APPLICATION NO. 03 DRB-01773	PROJECT NO. 1003041
PROJECT NAME Los Virils Subd.	
EPC APPLICATION NO. —	
APPLICANT / AGENT COLLATZ - R. HOWARD	PHONE NO. 897-2091
ZONE ATLAS PAGE C-20 <u>PgF</u>	
(SDP for SUB), (SDP for BP), (FINAL PLATS), (MASTER DEV PLAN), (IR), (AA)	
ONE STOP COMMENT FORM LOG

DESCRIPTION OF REQUEST: REPLAT LOTS 41-P1 & 42-P1 LOS UGILS INTO
LOTS 41-A-P1 & 42-A-P1 PREV. & FINAL PLAT

PLAT OF  
**LOTS 41-A-P1 AND 42-A-P1**  
**LOS VIGILS**

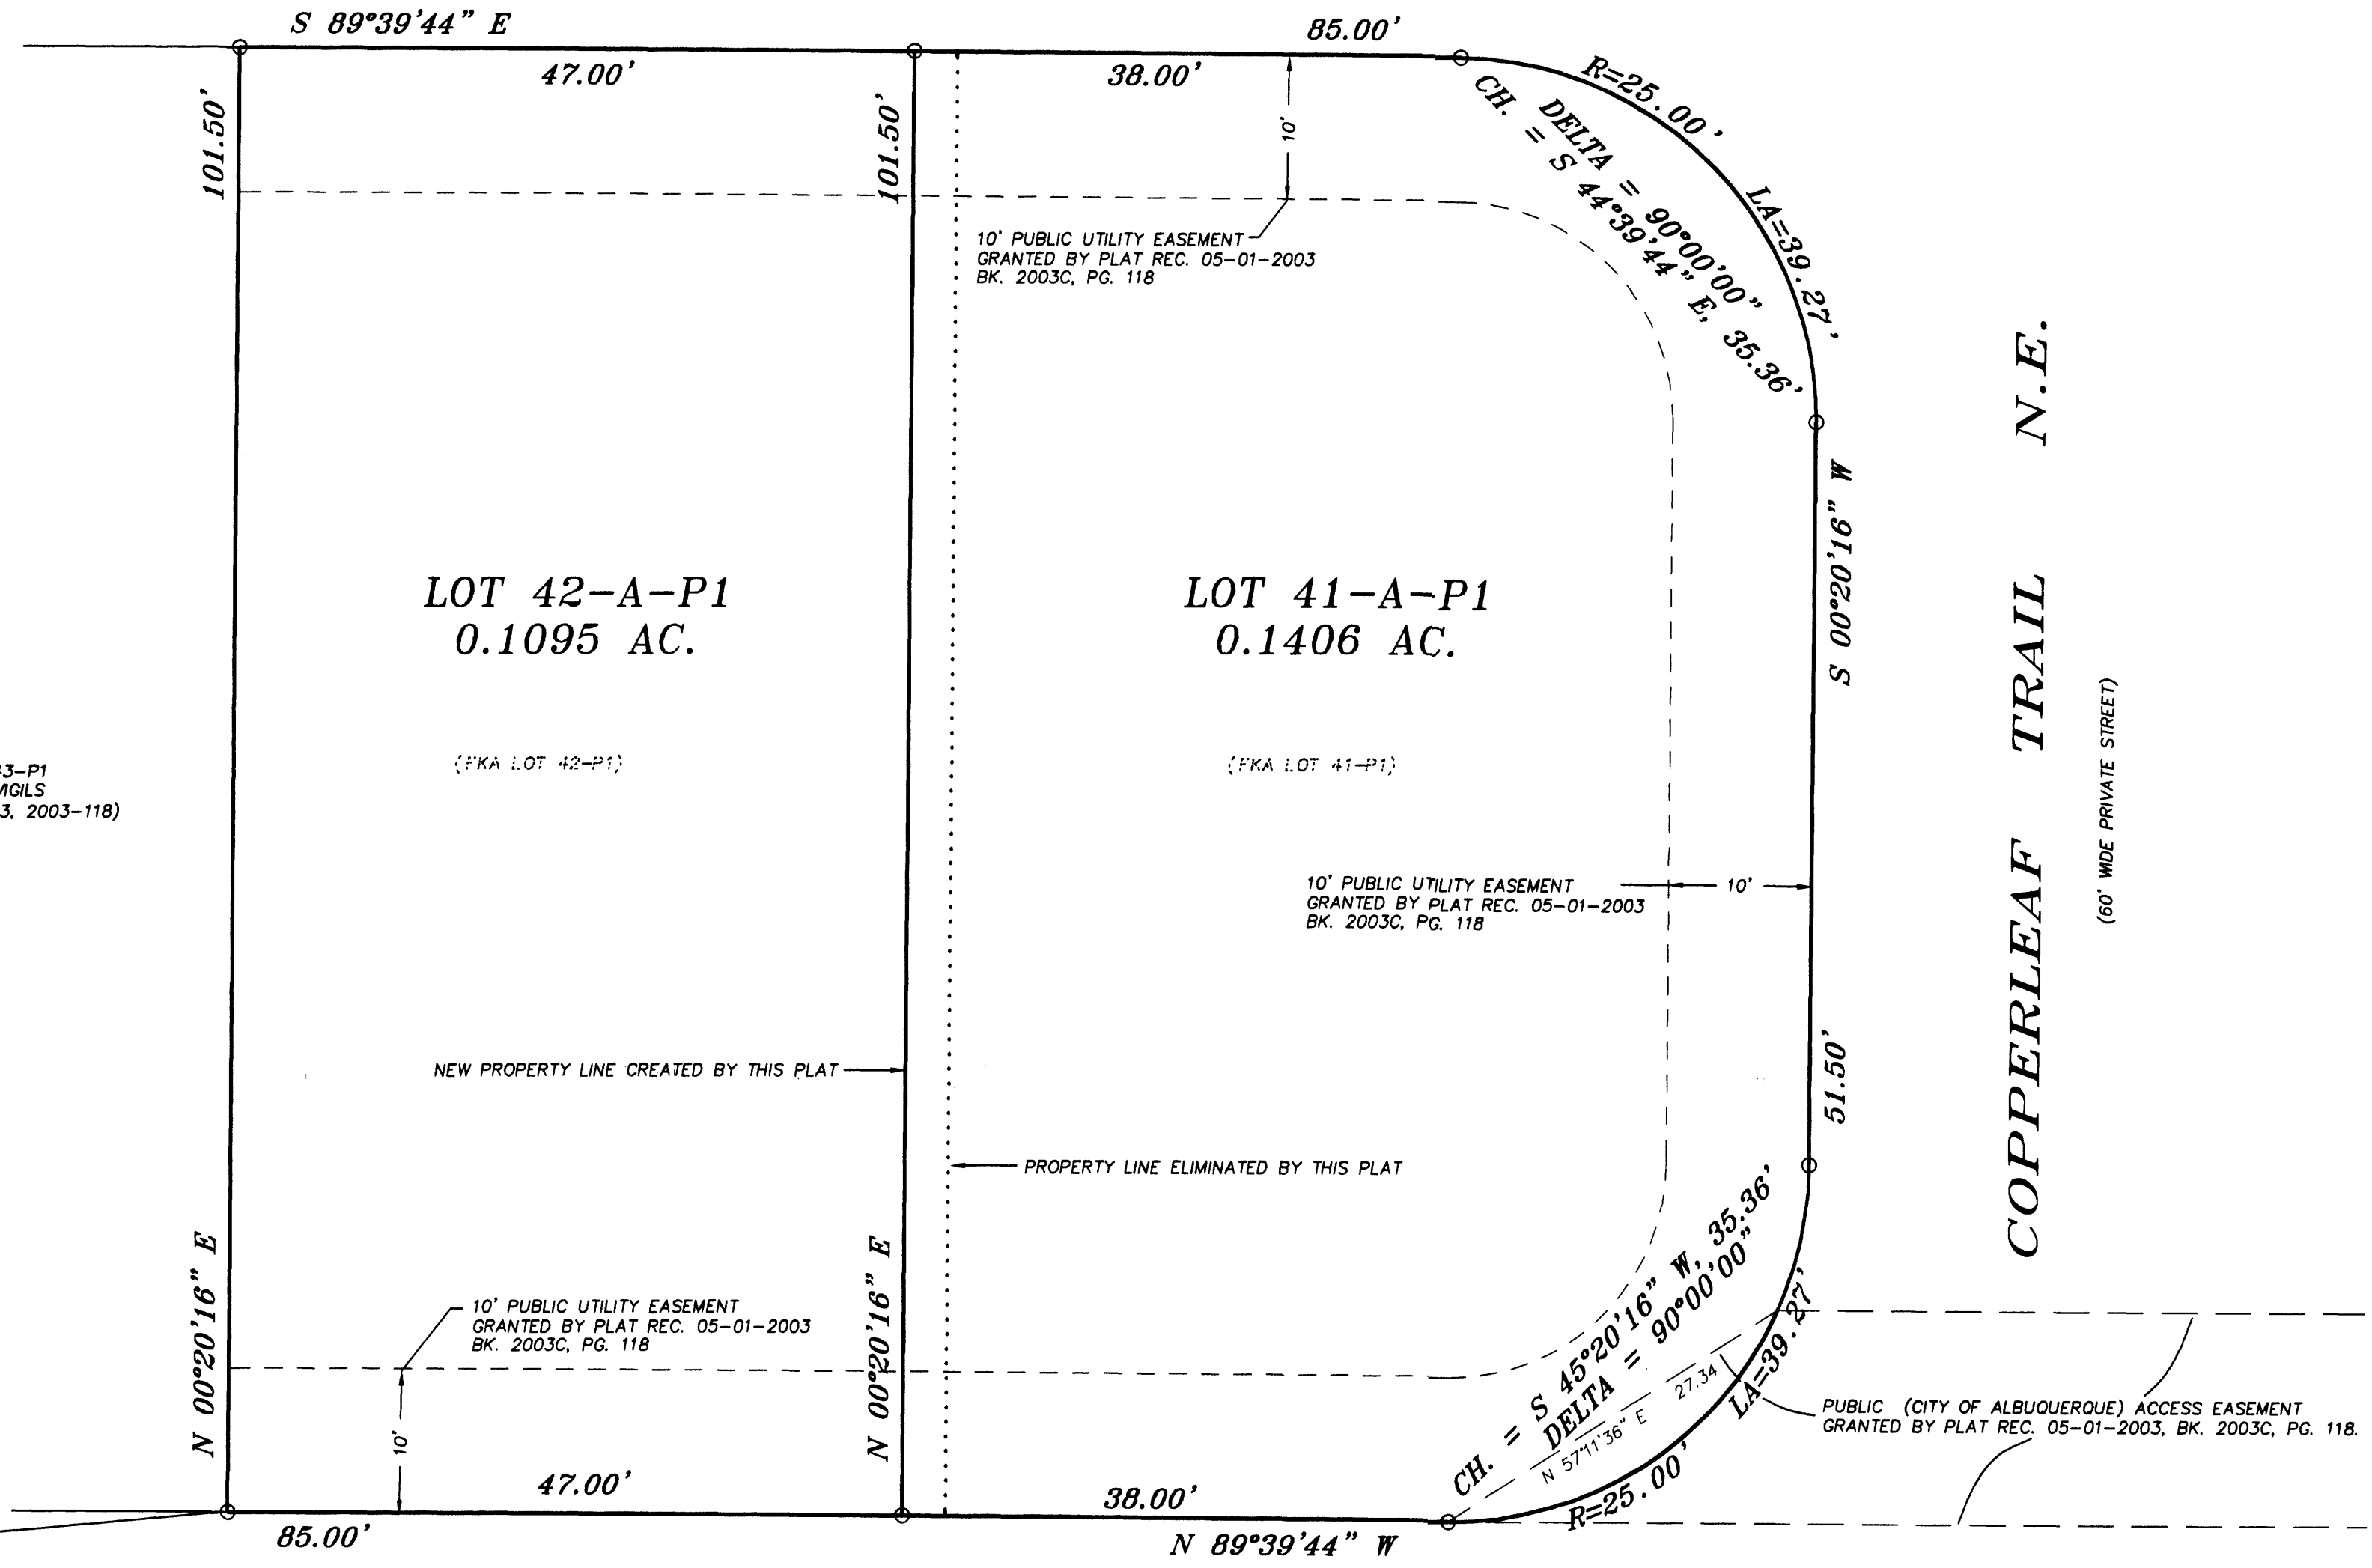
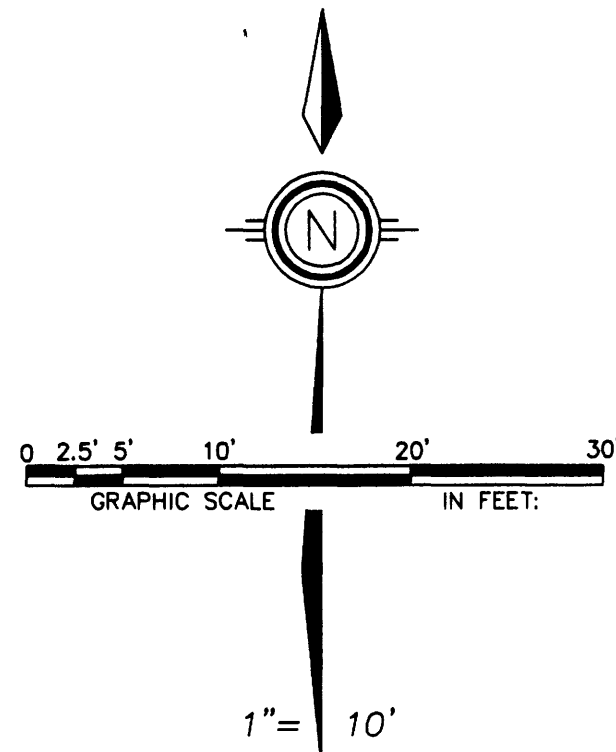
UTILITY DEV (505) 924-3989		
PLANS DISAPPROVED <u>NA</u>	DATE 10/18/03	DATE
PLANS APPROVED <u>NA</u>	DATE 10/30/03	DATE
COMMENTS:		
Where is meter box for the lots? If an old common lot line, must provide easement.
